KIRKLEES METROPOLITAN COUNCIL INVESTMENT & REGENERATION SERVICE

DELEGATED DECISION TO DETERMINE PLANNING APPLICATIONS

Reference No:	2026/62/90168/E
Site Address:	former Commercial Hotel, 125, Wellington Street, Batley, WF17 5TH
Description:	Erection of commercial unit for vehicle software diagnostics centre
Recommending Officer:	Danielle Cooper

Officer Report

Title:	PROPOSED BLOCK PLAN
Scale:	1:100@A1
Date:	JAN 26
Drawing No:	26/11-2
Revised:	-

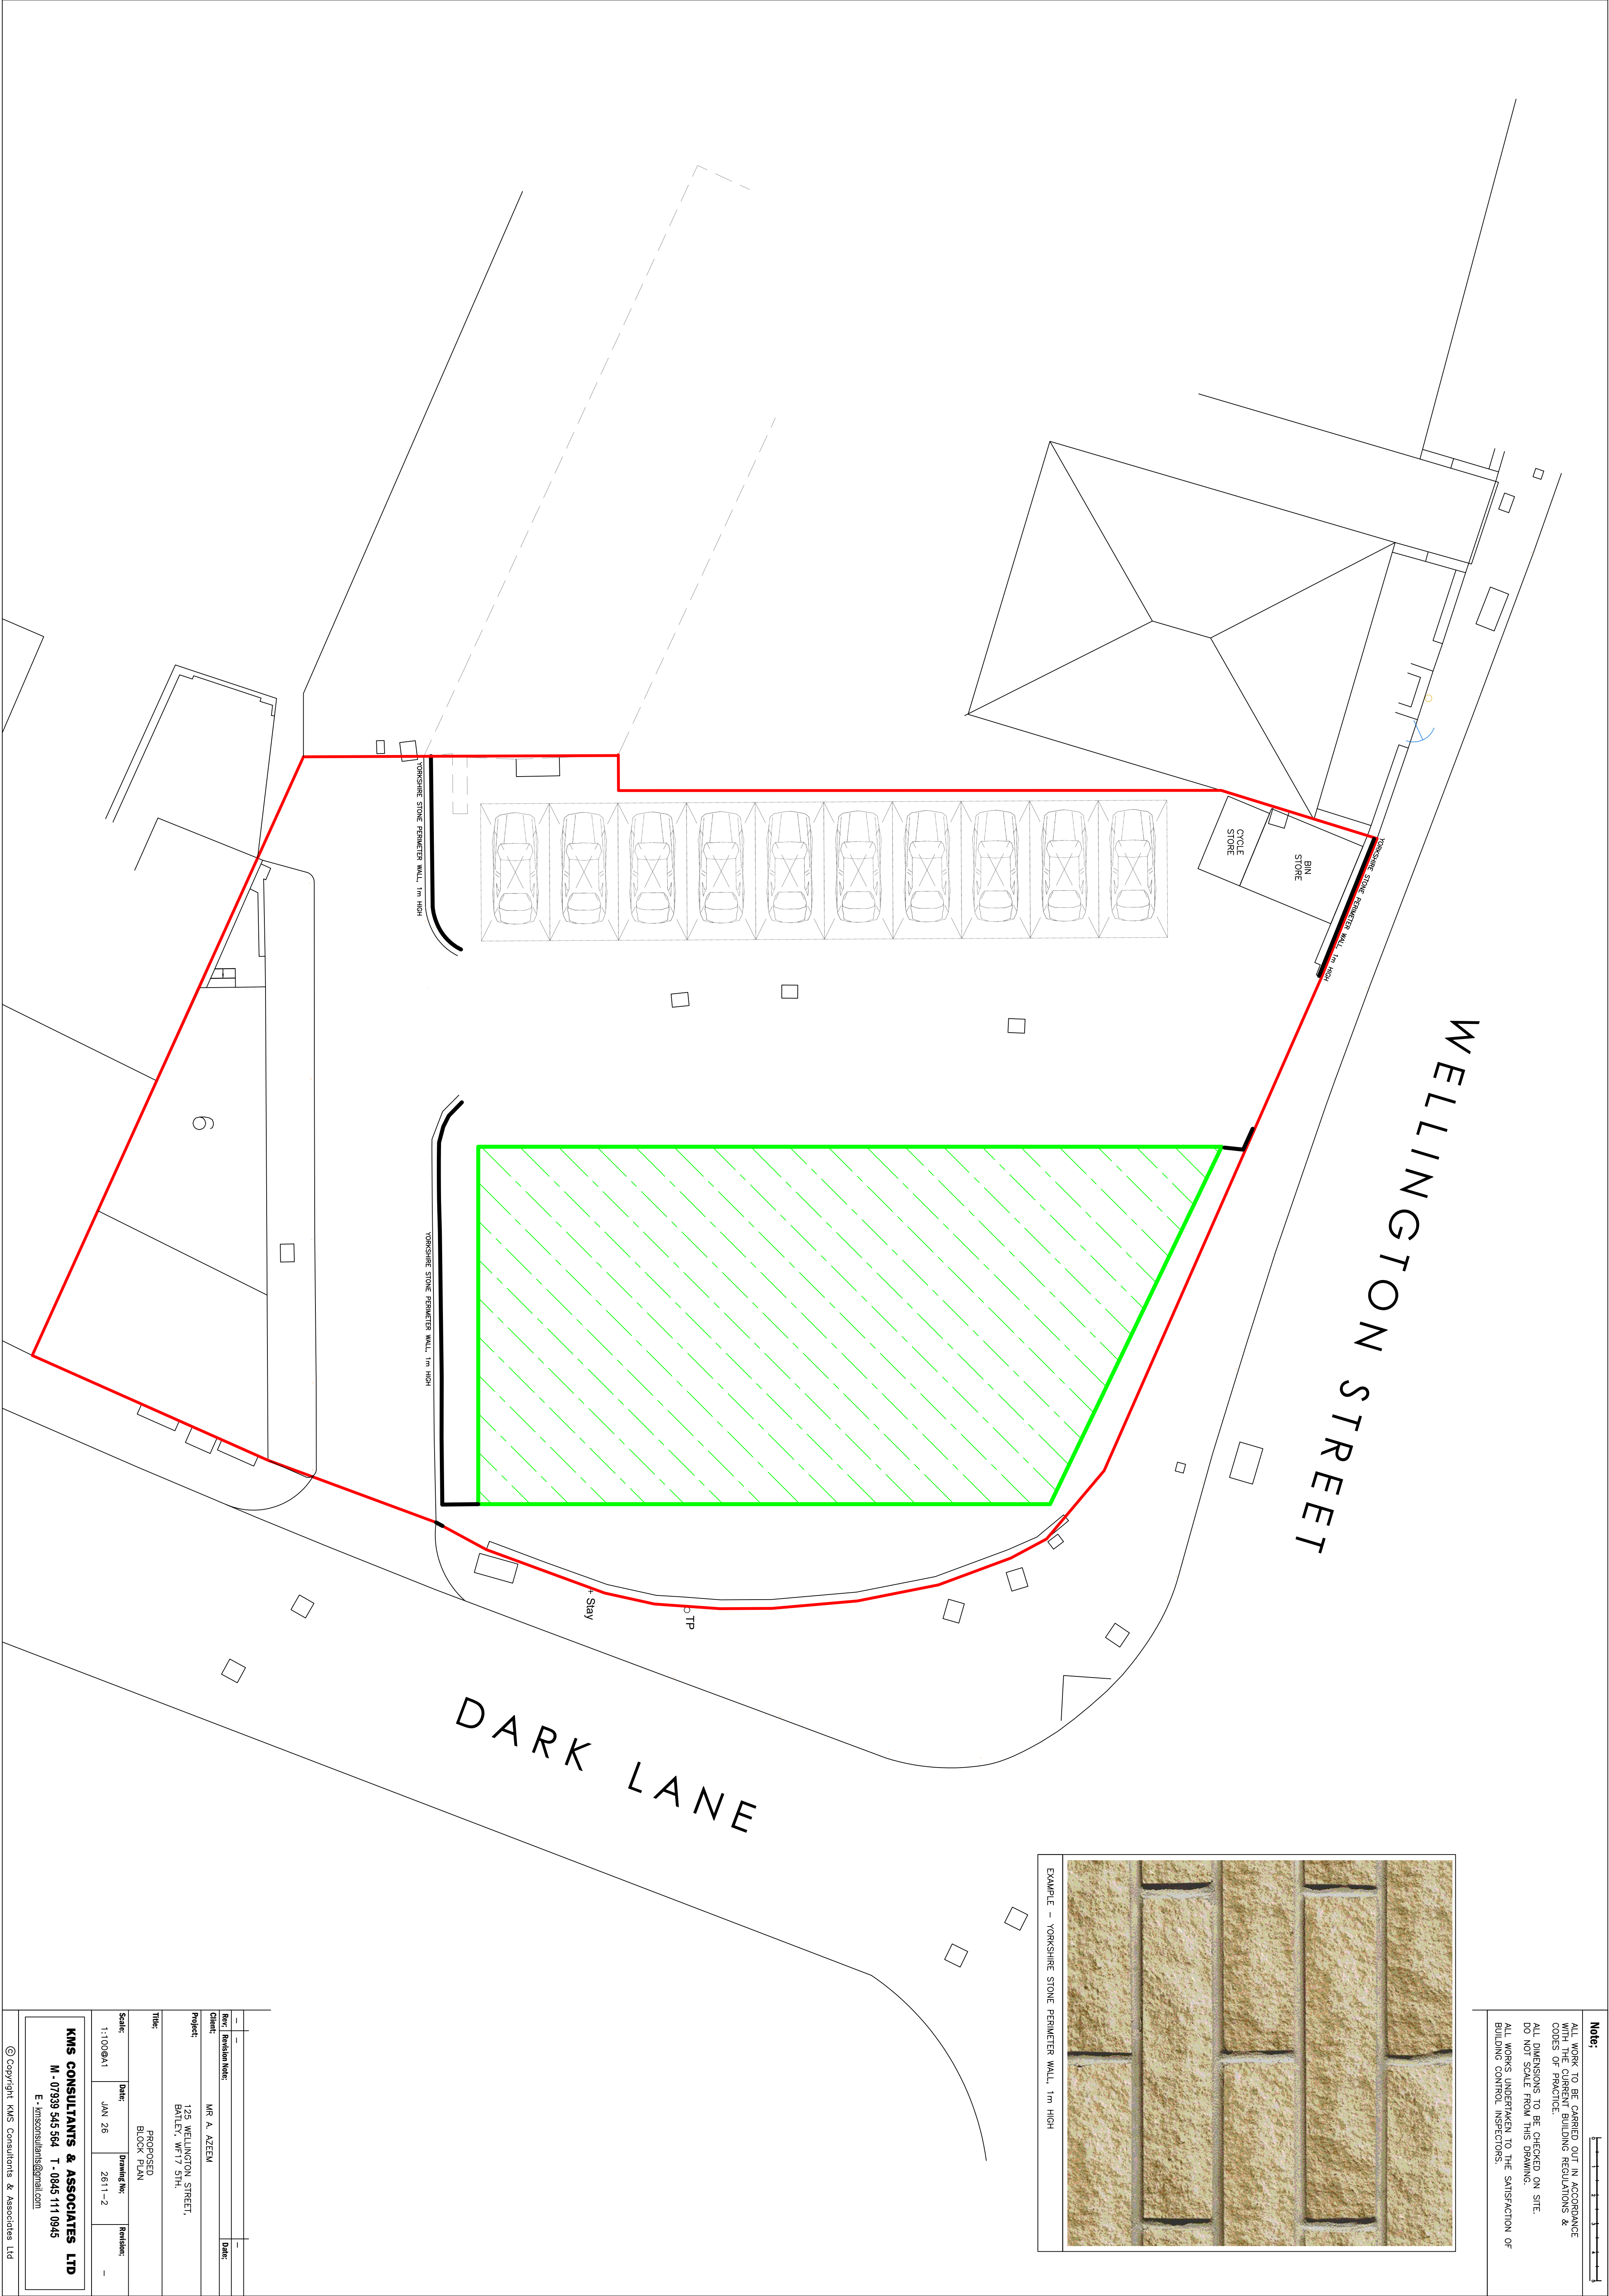
The site plan shows a 1m high Yorkshire Stone wall to the perimeter of the site which would be in keeping with the general character of the area and is therefore considered acceptable.

A cycle store and bin store are shown to the sides of the proposed unit. There are existing waiting restrictions to the Wellington Street and Dark Lane junction to control on street parking.

8. The development shall not be brought into use until the car park hereby approved has been laid out, surfaced and marked out into bays in accordance with the approved plan "2611-2A". All areas indicated to be parking areas must be laid out with a hardened and drained surface in accordance with the Communities and Local Government; and Environment Agency's 'Guidance on the permeable surfacing of front gardens (parking areas)' published 13th May 2009 as amended or any successor guidance. Notwithstanding the provisions of the Town and Country Planning (General Permitted Development) (England) Order 2015 as amended (or any Order revoking or re-enacting that Order) these areas shall be so retained, free of obstructions and available for parking thereafter.

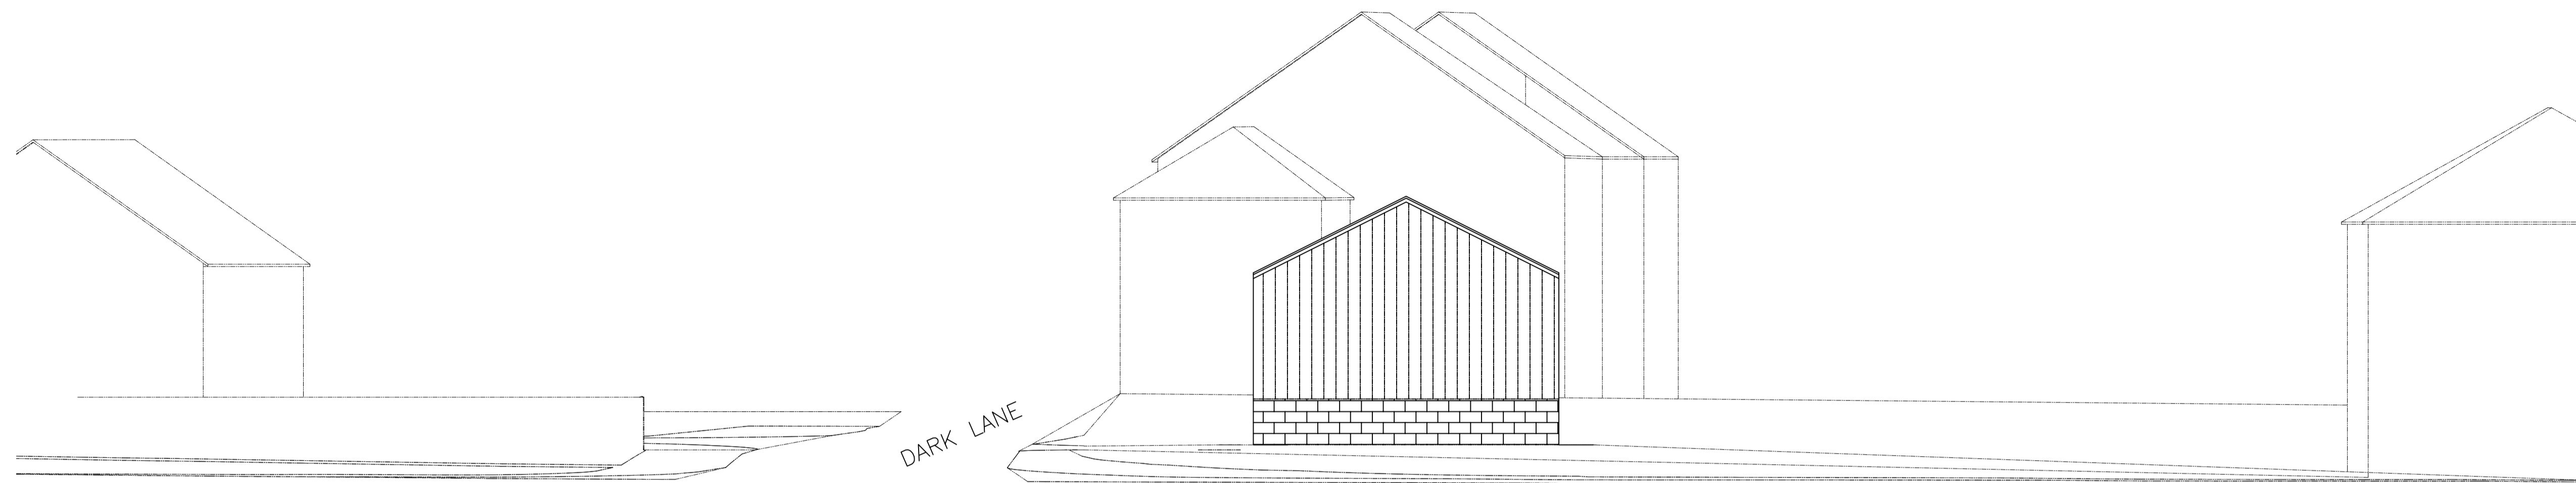
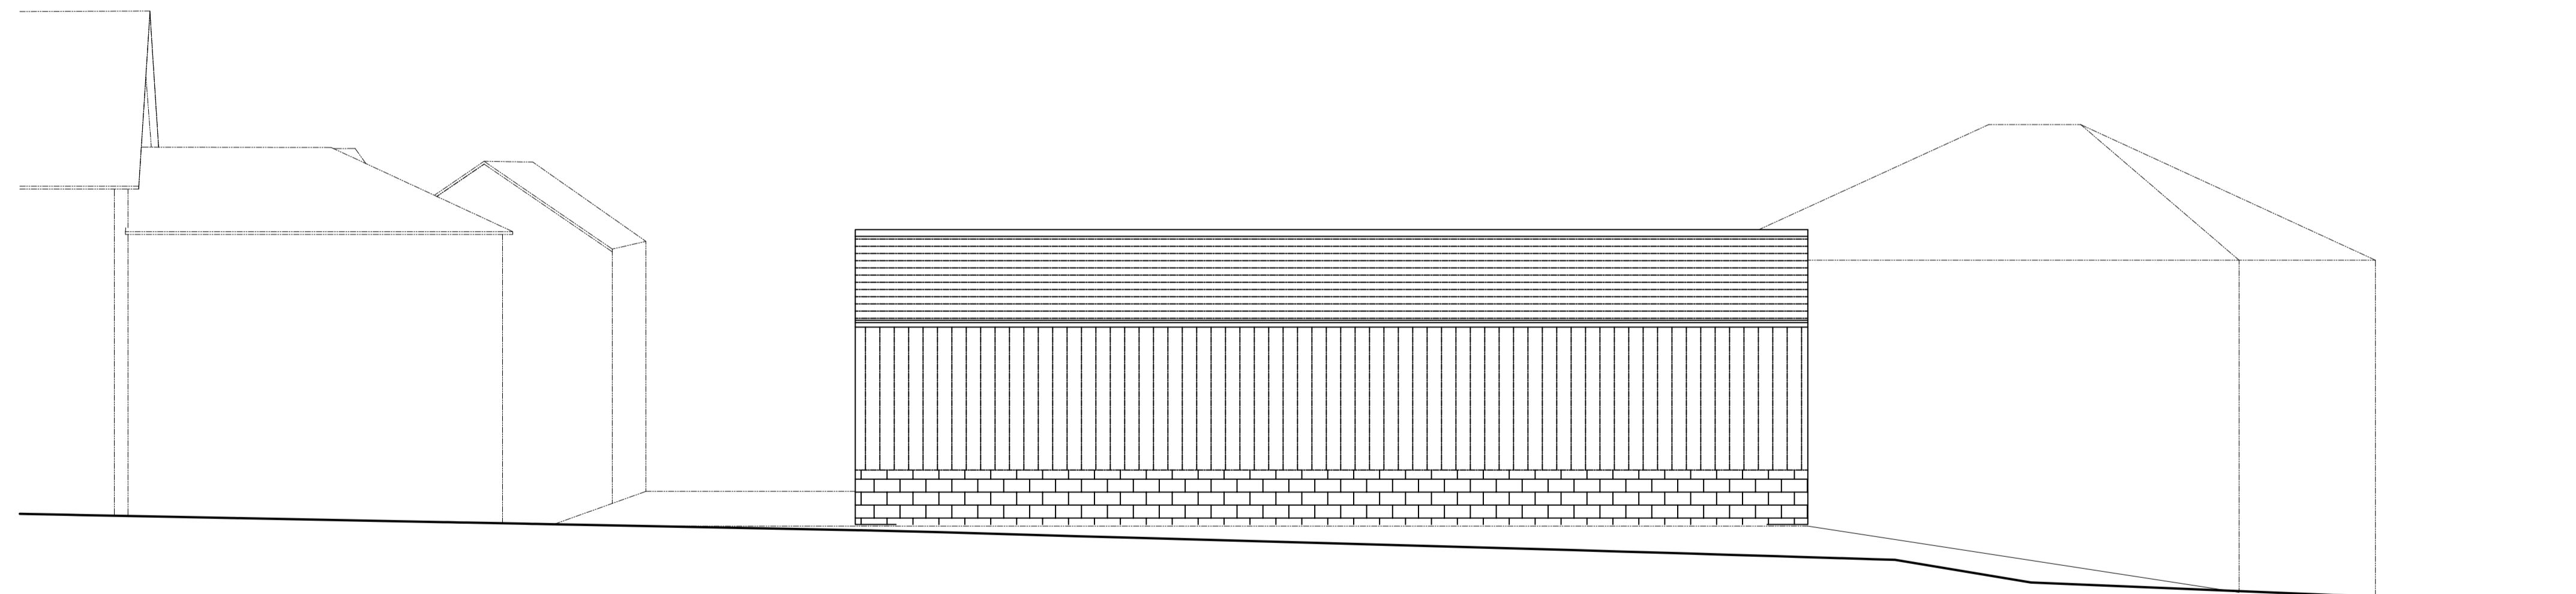
Whilst the location of the building along the eastern section of this site will result in the building appearing prominent within the street scene, the building, as amended, will be of the same footprint and scale as that approved under the 2024/92495 planning application. The location on balance is considered acceptable and would not warrant a refusal.

PROPOSED FRONT ELEVATION

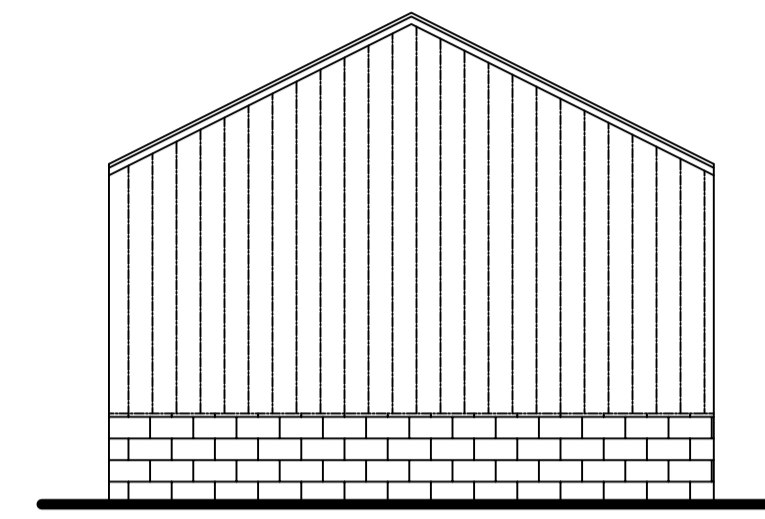
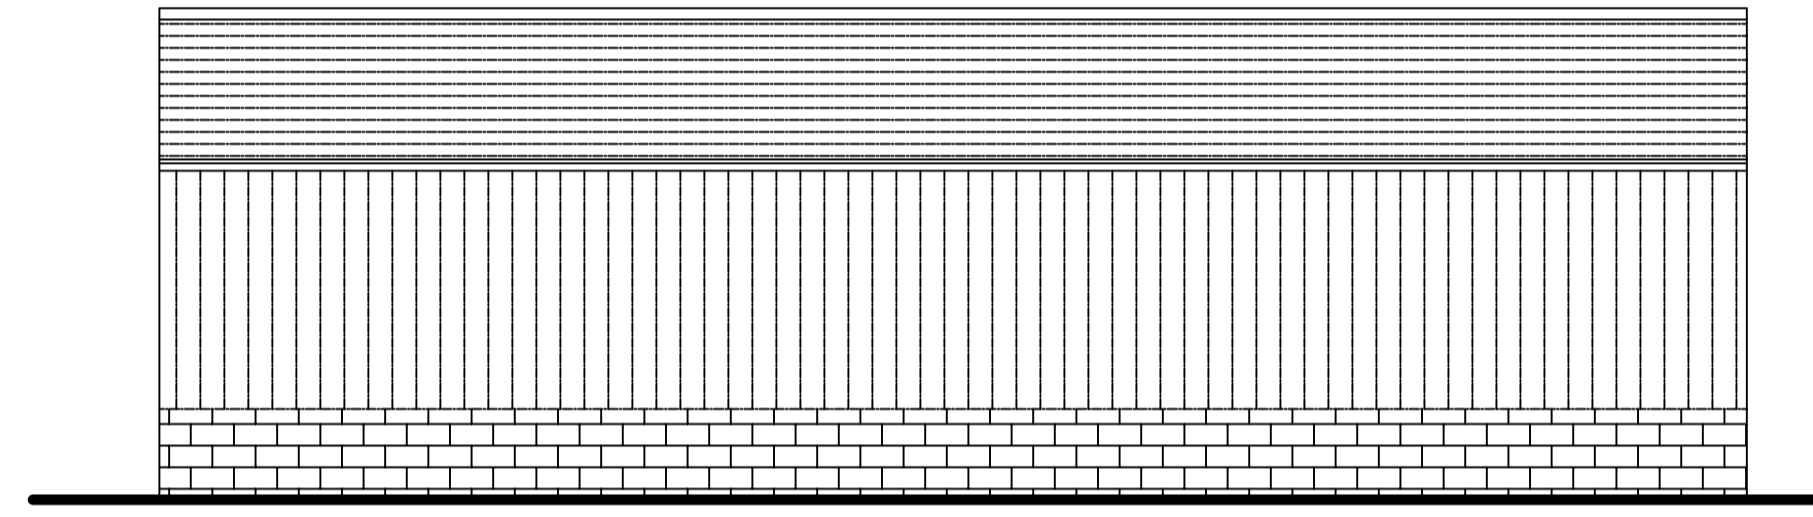
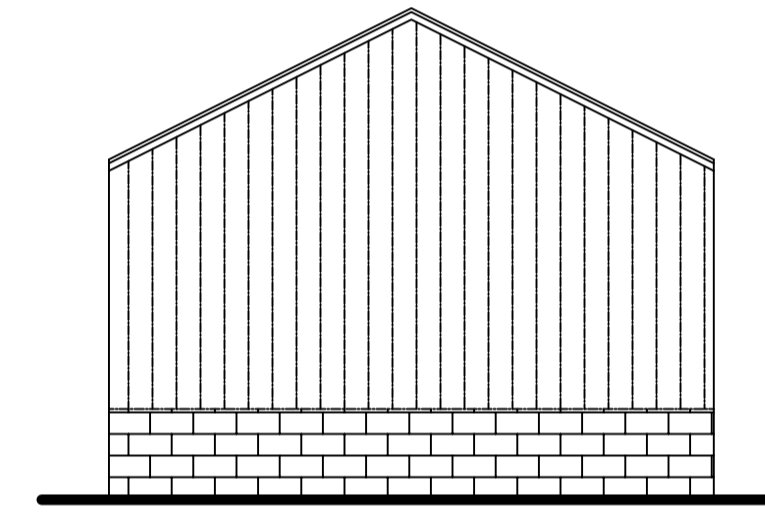
The scheme proposes a single storey, pitched roofed building to the eastern part of the site. The building would be 22m wide, 8m deep and would have a total roof height of 6.5m (4.5 to the eaves). There would be three large openings in the front to allow access for vehicles. It would be finished in aluminium cladding above a Yorkshire stone plinth. Aluminium cladding is also proposed to the roof.

The proposed building would be pitched roofed which would be in keeping with the general character of surrounding area. The applicant proposes aluminium cladding above a stone plinth to the walls and aluminium cladding to the roof. These are the materials that were approved under the 2024 application and as such there is no reason to raise concern regarding the materials proposed. The agent has also provided sample materials of the building via email on the 18th March 2026. It is considered that on balance the proposed use of aluminium cladding is acceptable and will not cause significant detrimental harm to the character and appearance of the immediate area. However, it is considered necessary in this case that a condition be imposed to ensure the sample materials are used in the construction the building.

3. The materials used in the development hereby approved shall be carried out in accordance with the submitted sample materials submitted via email on
